**State Significant Development Application and Variation of the Sydney Cove Redevelopment Scheme for the “*Remediation, Renewal and Adaptive Re-Use of Campbell’s Stores*”, The Rocks (SSD 7056)**

I write in response to the above development application (DA) and request to vary the Sydney Cove Redevelopment Authority Scheme (SCRAS) submitted to the Minister for Planning by Tallawolodah Pty Ltd for proposed works to the Campbell’s Stores at The Rocks.

Drawing Title  
**ELEVATIONS**  
JPW Project Number  
12006  
Drawing Status  
EA  
Drawing Number  
EA-A-2000  
Revision  
B

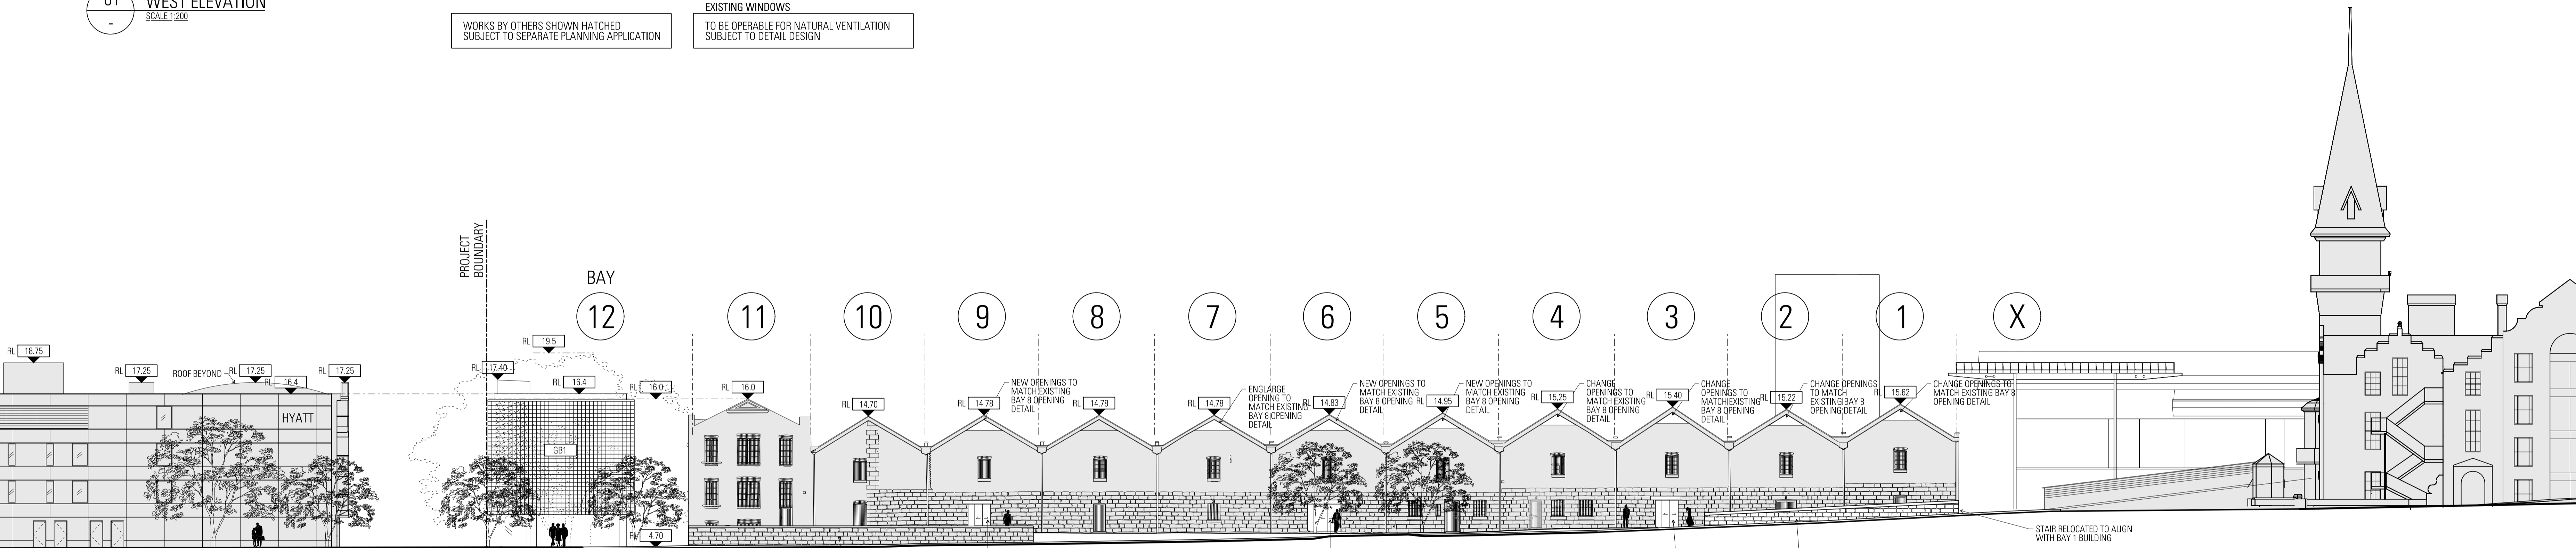
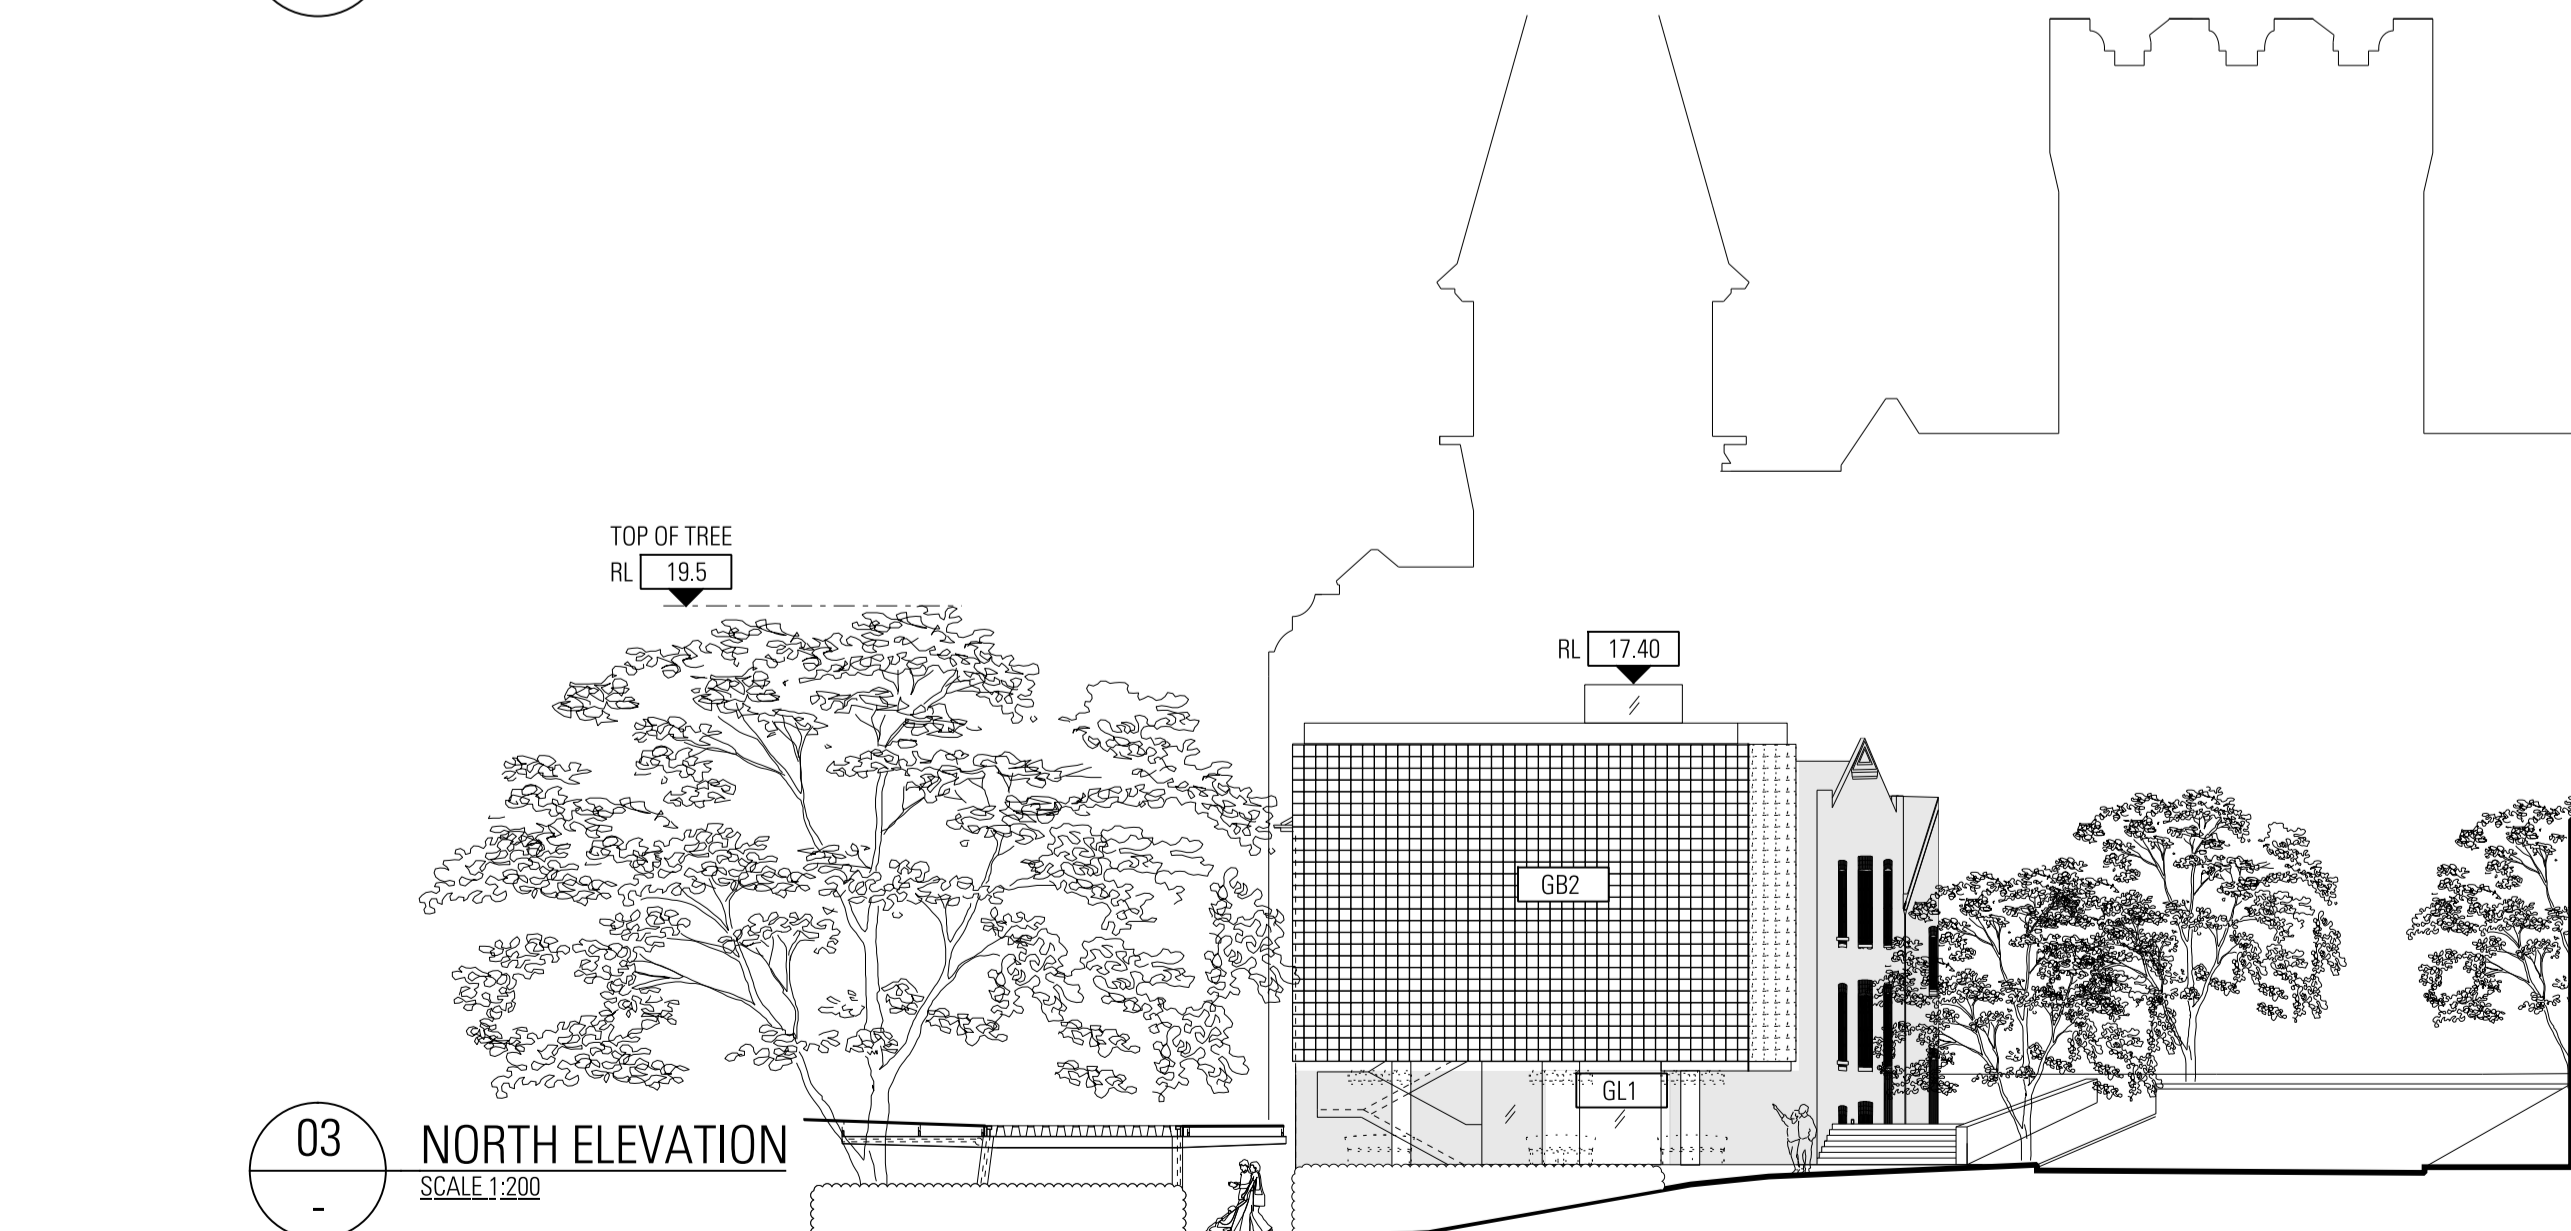
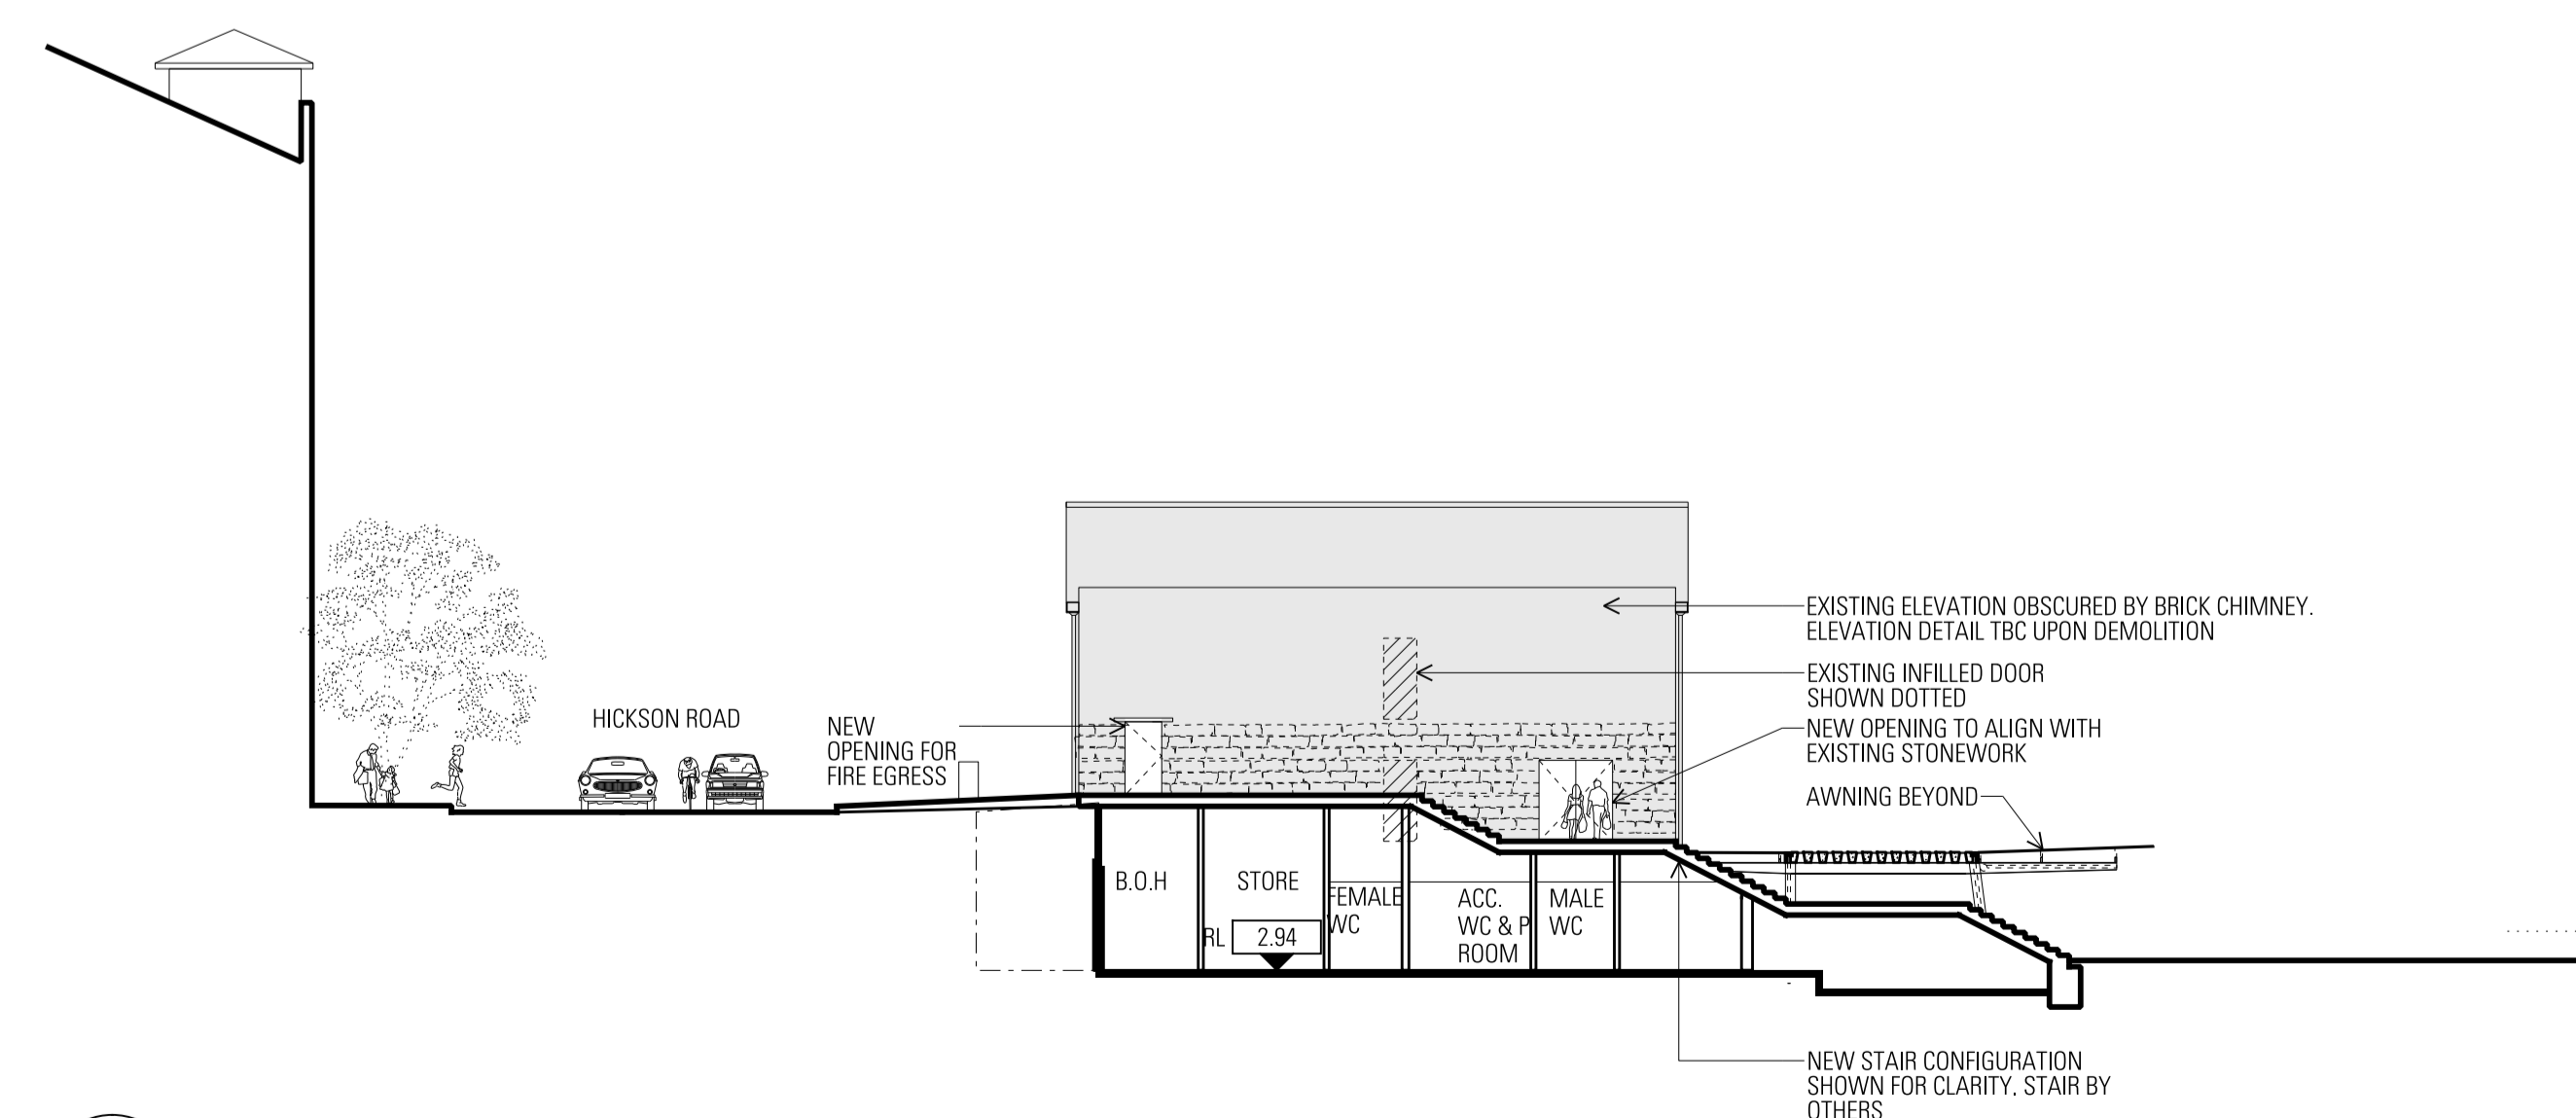
- The proposed new glass building does not comply with the current height limit and the applicant has applied for a "spot rezoning" to increase the height along the waterfront by more than five times the current permissible height limit - from RL3.5 to RL18.

- The proposal exceeds the height restriction on the foreshore **frontage by 14.5m, more than 250% and on the Hickson Road elevation by 10.5m, or 140%.**

- There is no detailed description about works to Hickson Road, such as loss of on street car parking or specific details about outdoor seating and dining. The Hickson Road frontage of Campbell's Stores is the only elevation that remains visually uncluttered and relatively unaltered, retaining its simply detailed, 19th century industrial character and is an important component of the overall heritage significance of the place.

- The current proposal involves the introduction of new uses to the Hickson Road frontage. It involves unsympathetic alterations to existing openings including new concrete entry portals with back-lit signs and potentially the introduction of chairs and tables, umbrellas and street trees. The end result will be that the Hickson Road frontage will be cluttered, visually obscured and the ability understand the original form and use of this building of 'Exceptional' heritage significance will be reduced.
